From: Laura Gibbons <Laura.Gibbons@arun.gov.uk>
Sent: 22 March 2022 11:36
To: Planning.Responses <Planning.Responses@arun.gov.uk>
Cc: Simon Davis <Simon.Davis@arun.gov.uk>
Subject: RE: Planning Re-Consultation on: P/15/22/DOC

Engineers Further Comments Regarding Conditions 9-11

Application No: P/15/22/DOC
Registered: 9th February 2022
Site Address: Land adjacent to Sefter School House Sefter Road Bognor Regis PO21 3EE
Grid Reference: 489528 99491
Category: Discharge of Condi
Description of Works: Approval of details reserved by condition imposed under ref P/116/19/OUT relating to Condition Nos 9 - surface water drainage, 10 - discharge flows to watercourses, 11 - maintenance & management of surface water drainage, 12 - foul drainage assessment, 13 - contamination, 14 - Construction Management Plan and 15 - Arboricultural Impact Assessment.

Scale	1:200 on A1	Drawn	JH
Date	08/10/2021	Checked	TL
File	21-023-Acad-003	Drawing No	21-023-003
		Rev	A

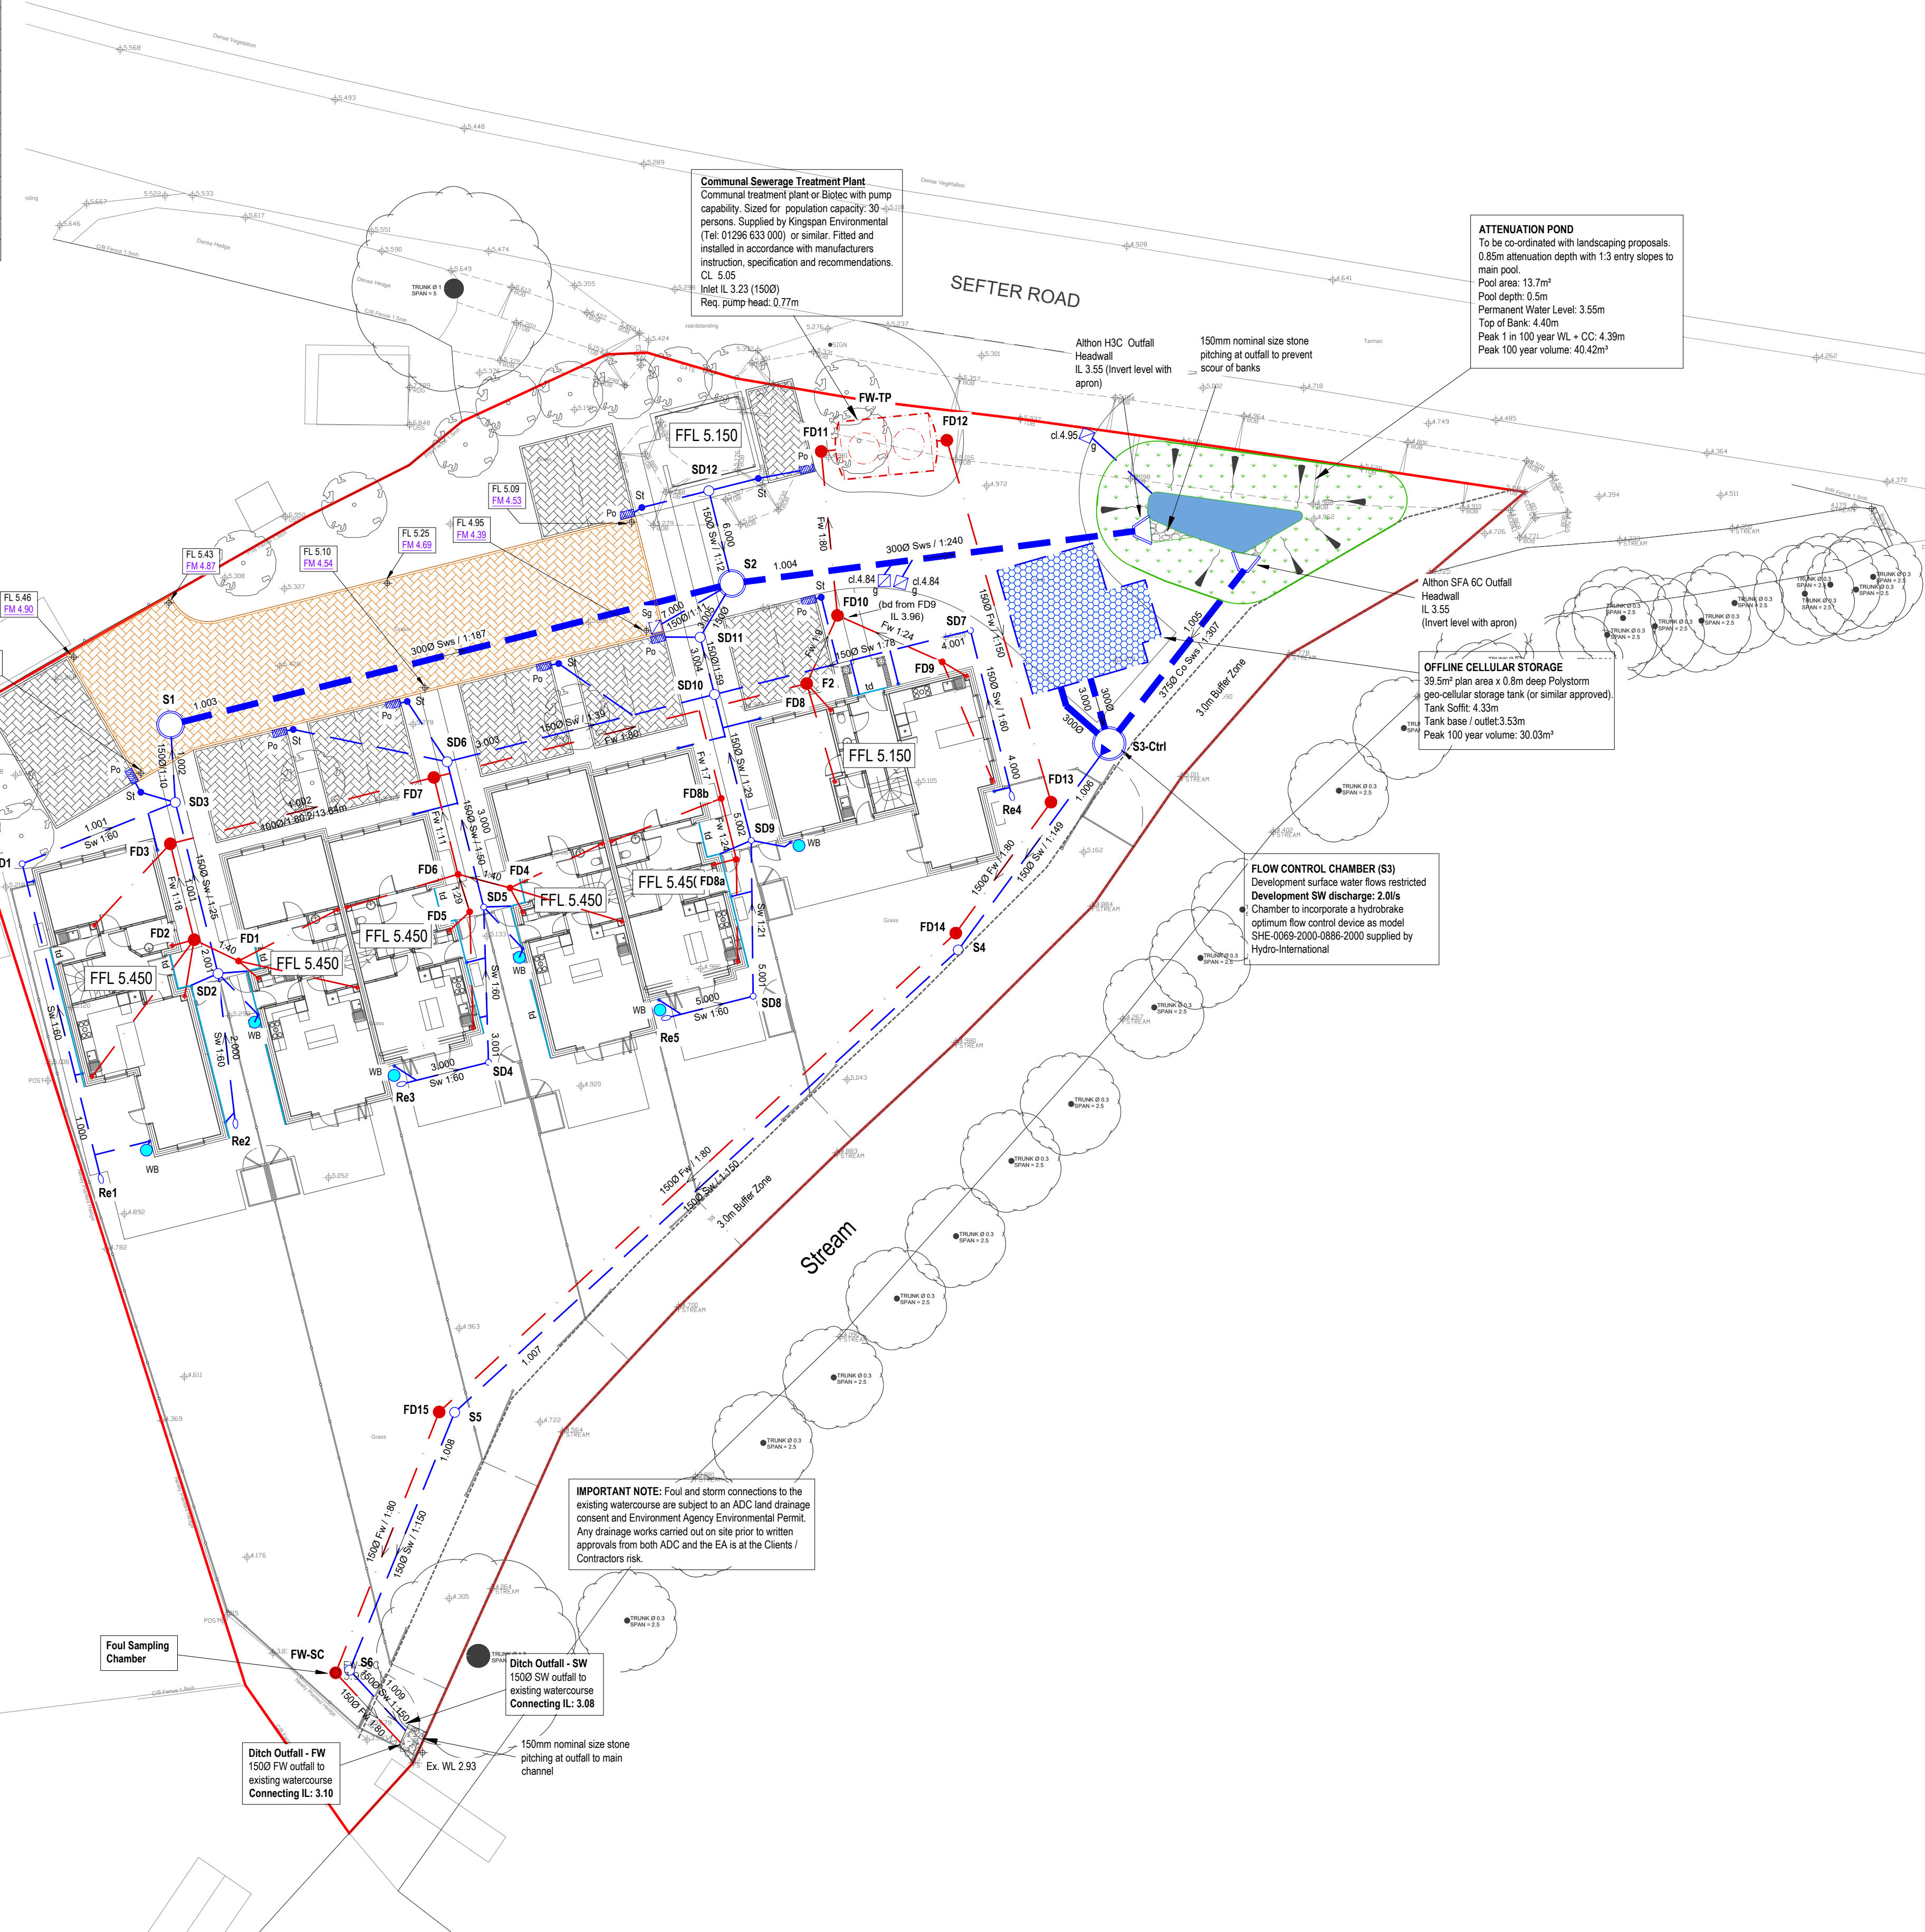
9. "Finish and formation level of permeable paving must be labelled on layout plan".

10. "All pipes must be labelled with diameter and fall".

11. "Please label gully cover levels on plan".

12. "Hydrobrake unit reference must be stated on plan".

13. "Please show connections from permeable paving areas to the piped network."

Finished and formation levels for the main access permeable paving have now been included on the updated drainage layout plan.

Noted. Now illustrated on the Below Ground Drainage Layout in Appendix F. *Okay.*

Noted. Updated accordingly *Okay.*

Noted. Updated accordingly *Okay.*

Noted. Updated accordingly *Okay.*

SECTION THROUGH ATTENUATION POND
(SCALE: 1:20)

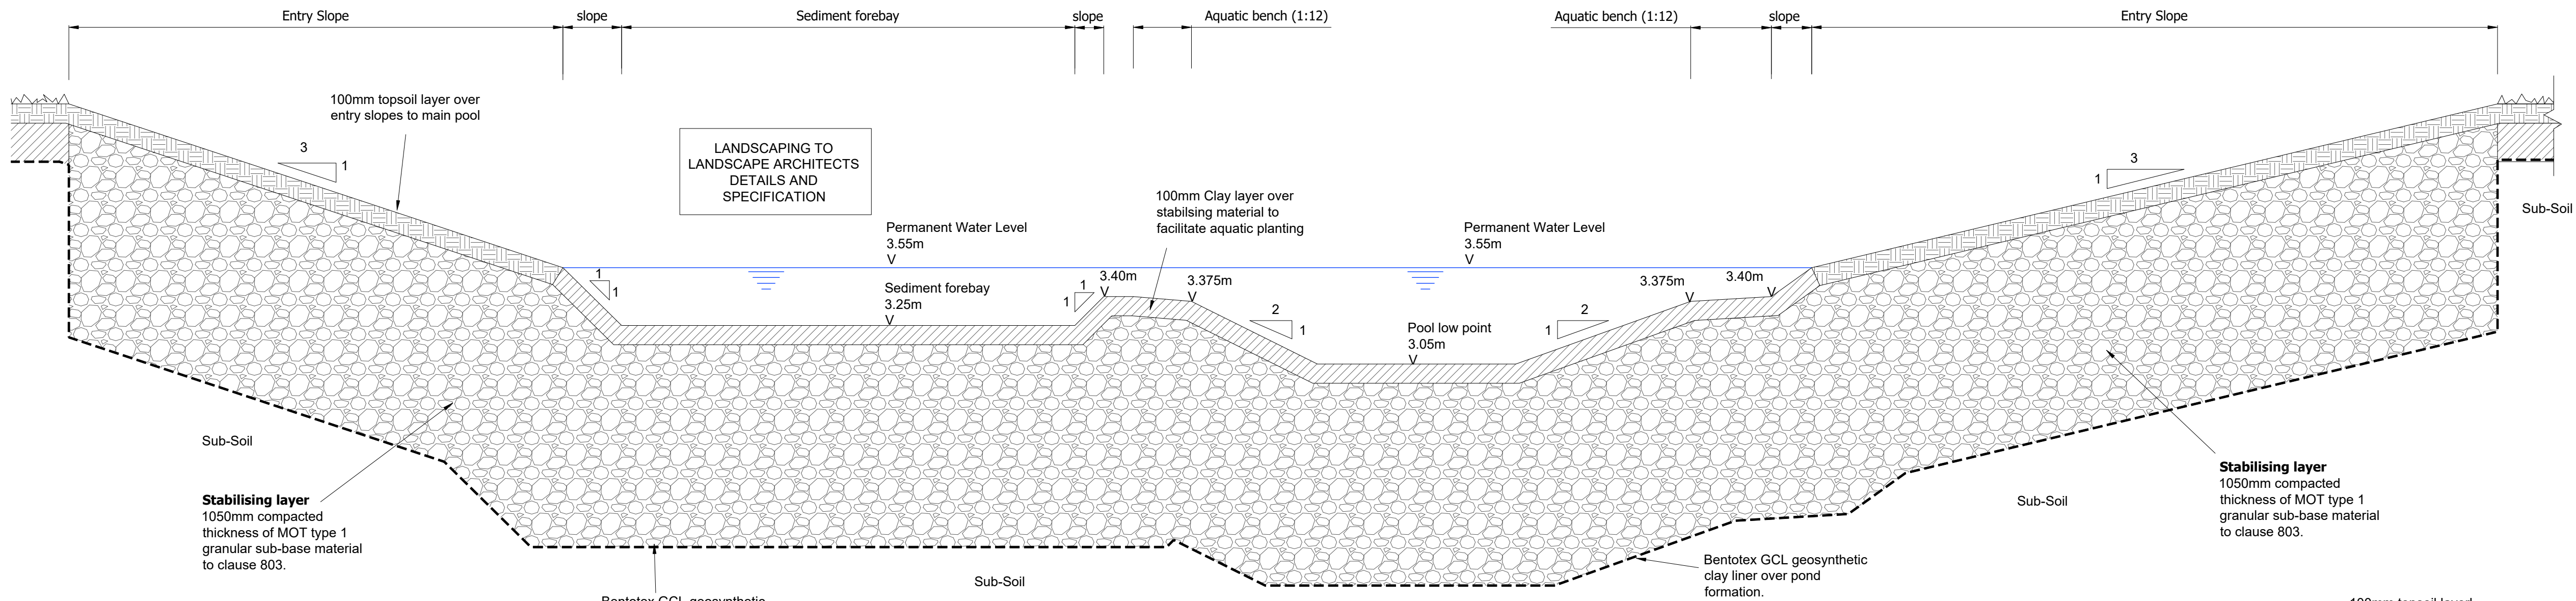
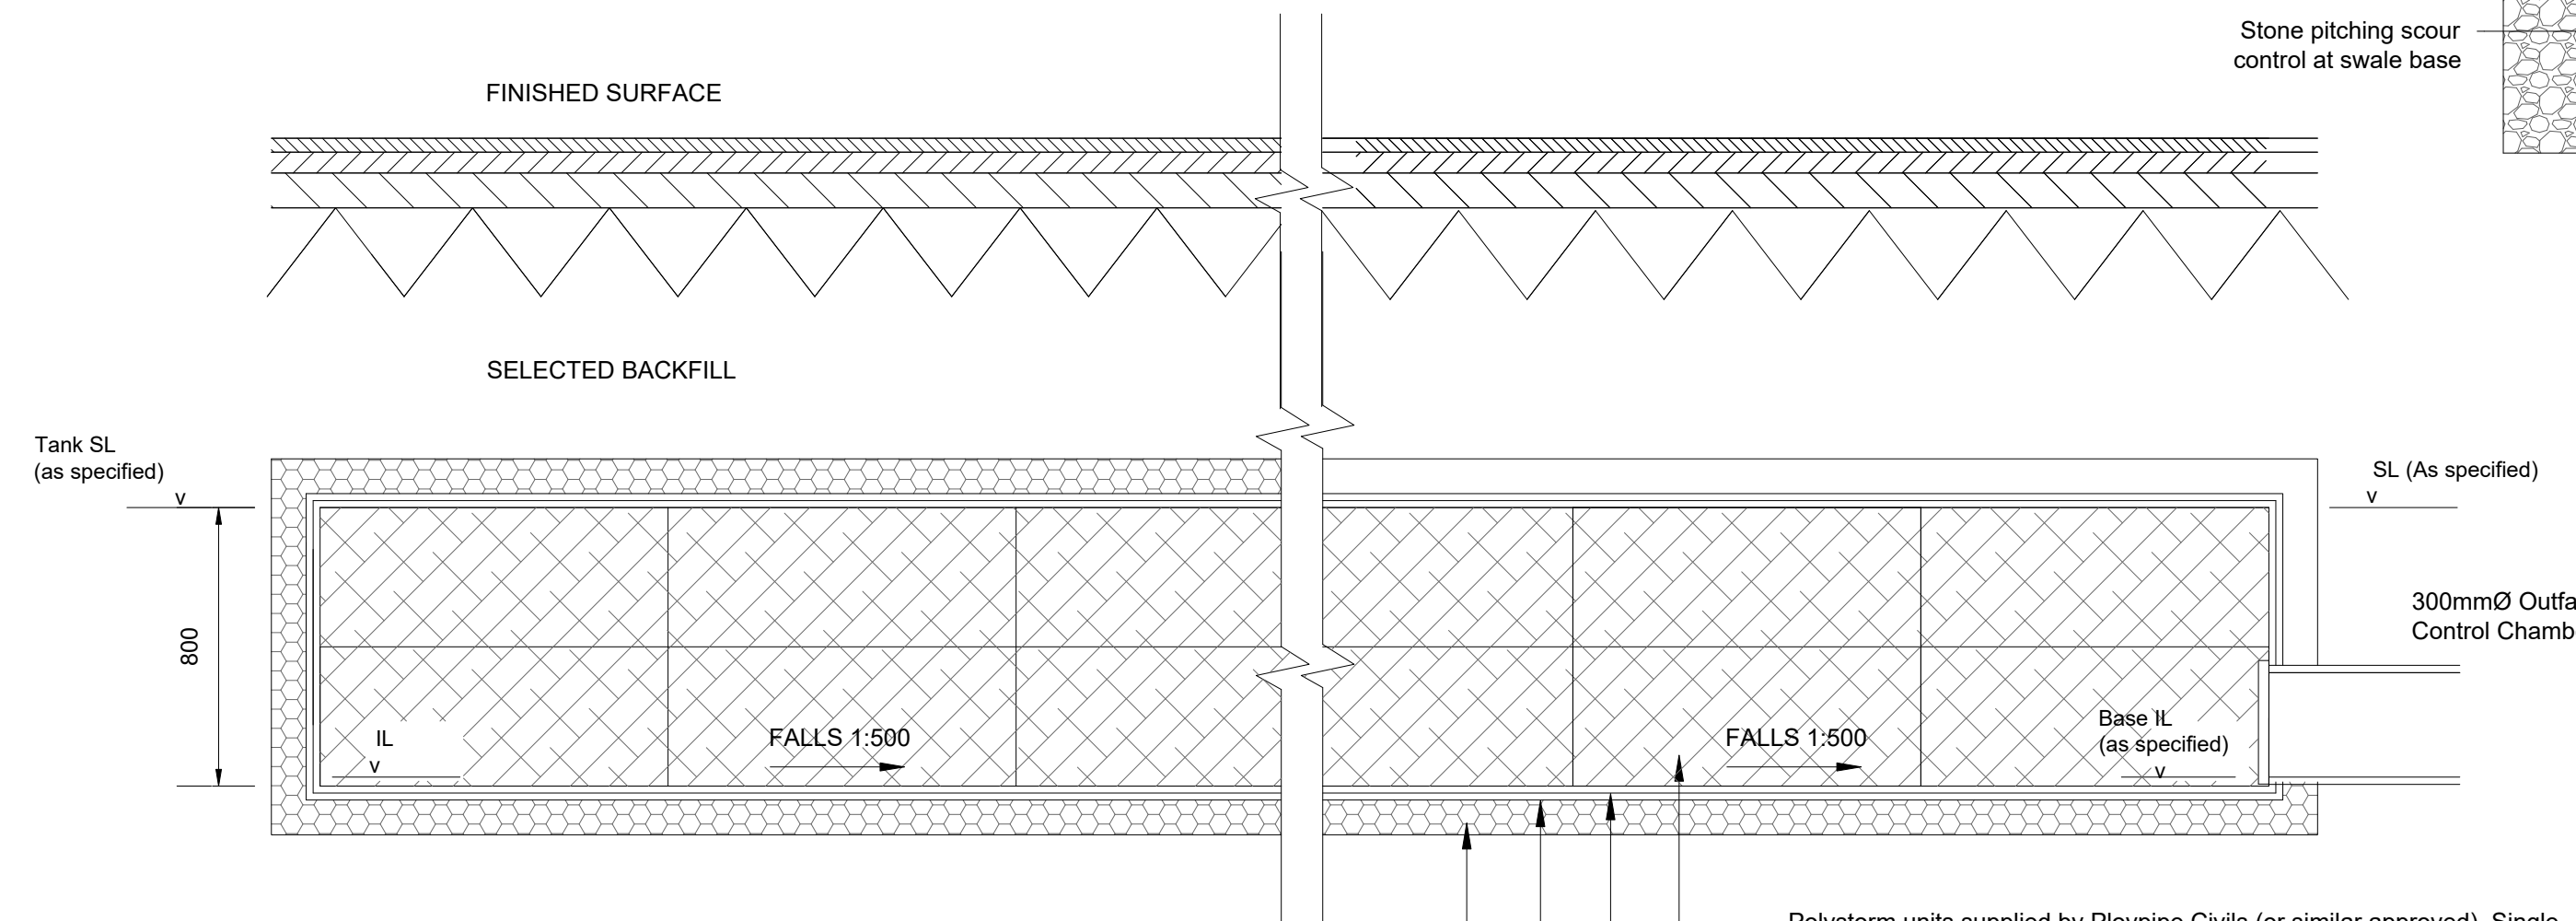
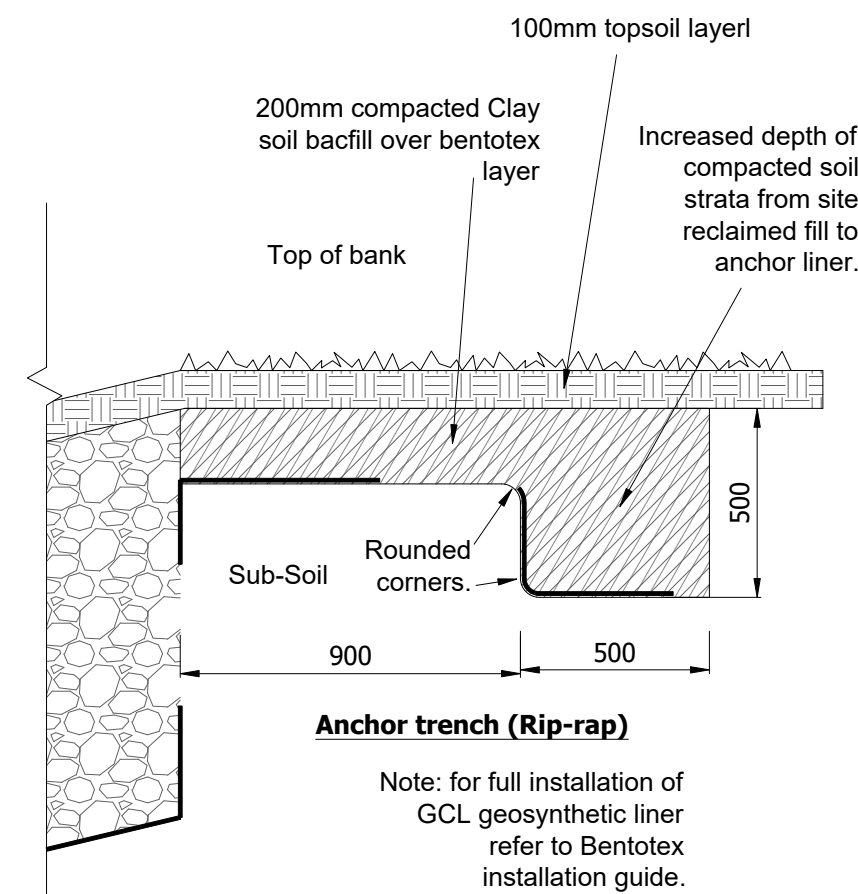
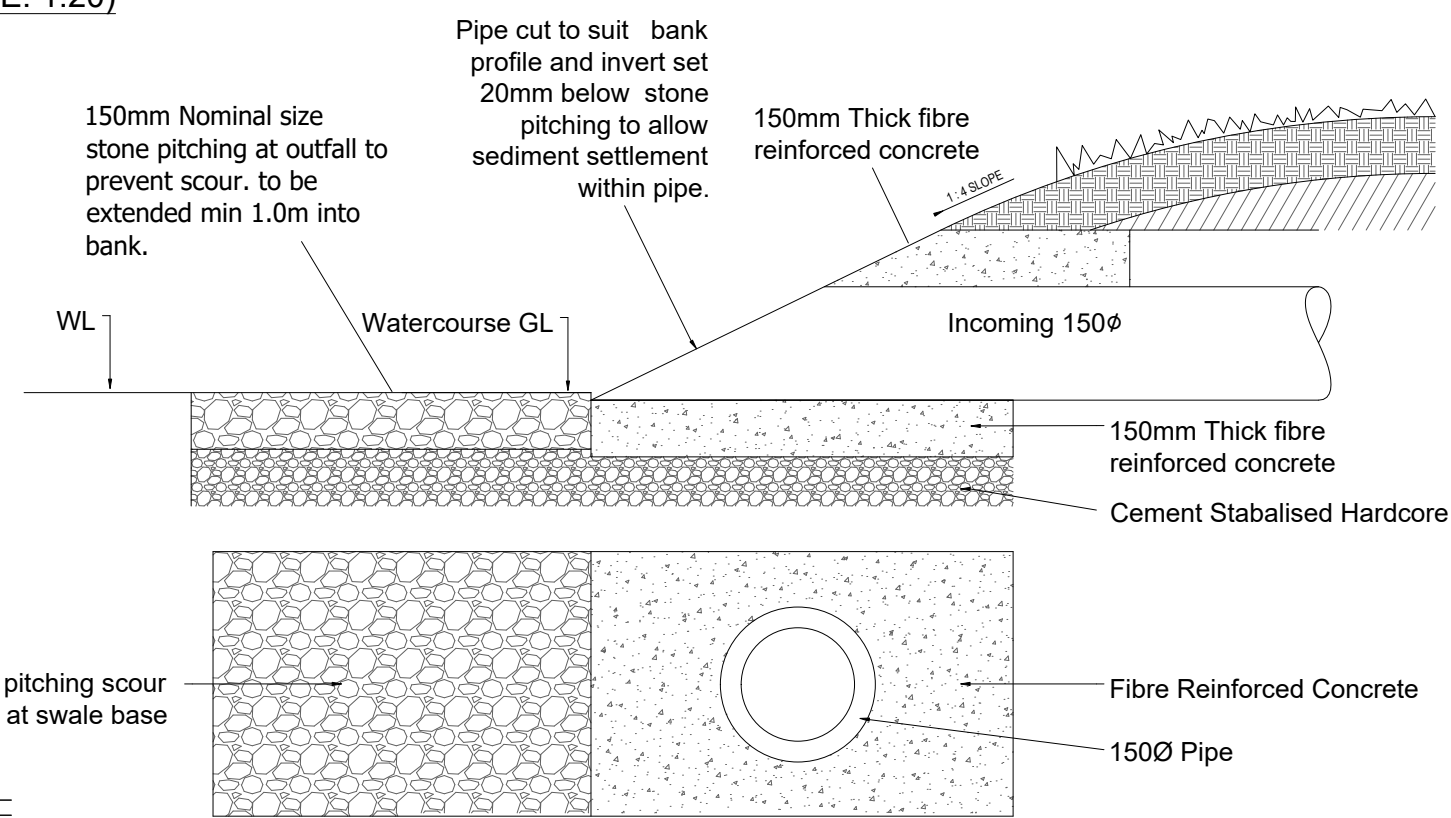
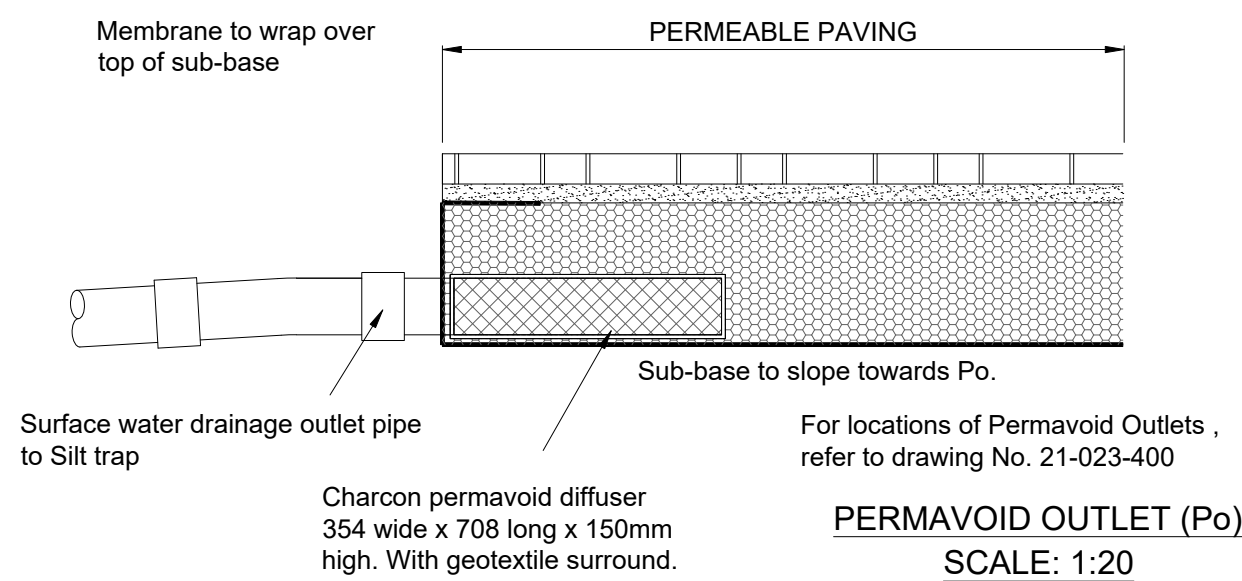
A full set of site specific drainage construction details has been included within Appendix H. *Please submit a land drainage consent application for the two proposed outfalls. The outfall as shown within the construction details will need improving. We will need to see invert levels, hard bed levels, bank levels, existing bank profile, etc. shown.*

Please provide a further basin cross section. Please detail how separation of topsoil and Type 1 in basin will be provided. We would suggest a 45 degree cranked grille should be provided to the 375mm diameter pipe out of the basin, please consider.
